From: Tim Rodway | Rodway Planning [REDACTED]
Sent: 09 July 2019 12:50
To: Planning.Responses; Nicola Spencer
Cc: Maria Tomalova
Subject: RE: FP/274/18/PL, 10 Felpham Gardens
Attachments: Prop FF Plan Unit 1.pdf

From: Maria Tomalova
Sent: 19 June 2019 10:01
To: Planning.Responses <Planning.Responses@arun.gov.uk>
Subject: FW: FP/274/18/PL, 10 Felpham Gardens

From: Maria Tomalova <Maria.Tomalova@arun.gov.uk>
Sent: 18 June 2019 18:56
To: Tim Rodway | Rodway Planning [REDACTED]
Subject: RE: FP/274/18/PL, 10 Felpham Gardens

PROPOSED ELEVATIONS
UNIT 1

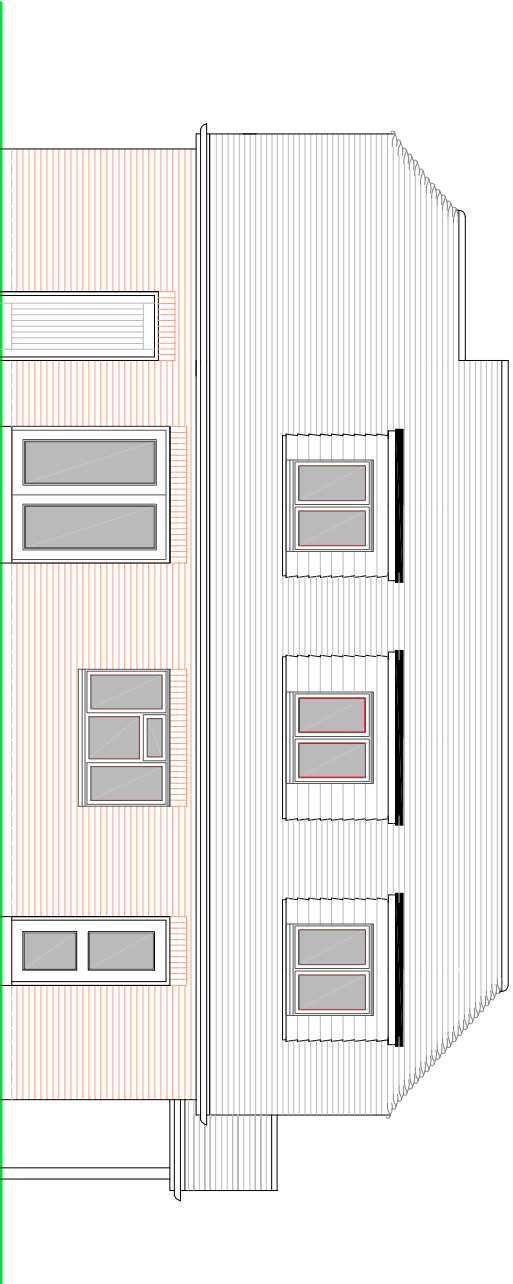
In the submitted drawings of Unit 1, Northern Elevation the dormers window are shown openable and with a clear glass.

I would advise you to amend this drawings showing the windows of the proposed dormers non openable up to 1.7m and obscure glazed to avoid confusion.
